Tracy Bellamy - FW: Third Track Proposal

From: Robert Claxton <rcclaxton@hotmail.com>
To: <plan_comment@planning.nsw.gov.au>
Date: 4/11/2012 2:06 PM
Subject: FW: Third Track Proposal
Attachments: scaThird Track S0001.pdf

Epping to Thornleigh Third Track Proposal. Application number SSI 5132.

Figure 5.6 Cross-section and elevation - New Cheltenham Station concourse building
Note: Indicatively added to future design

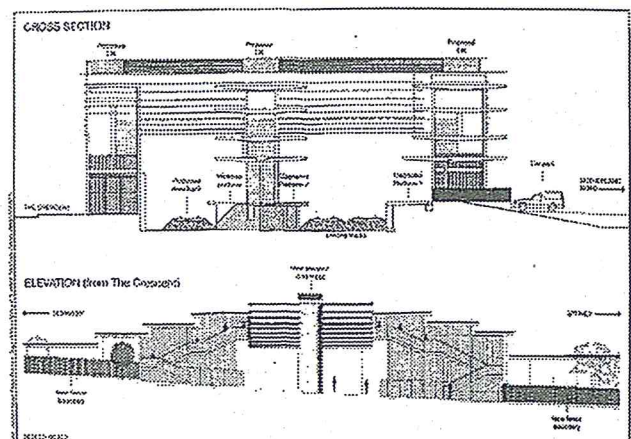
- The proposed redevelopment of Cheltenham Station shows no regard for the HCA. The visual impact of the proposed 13m high glass and steel concourse is totally unacceptable in this HCA.
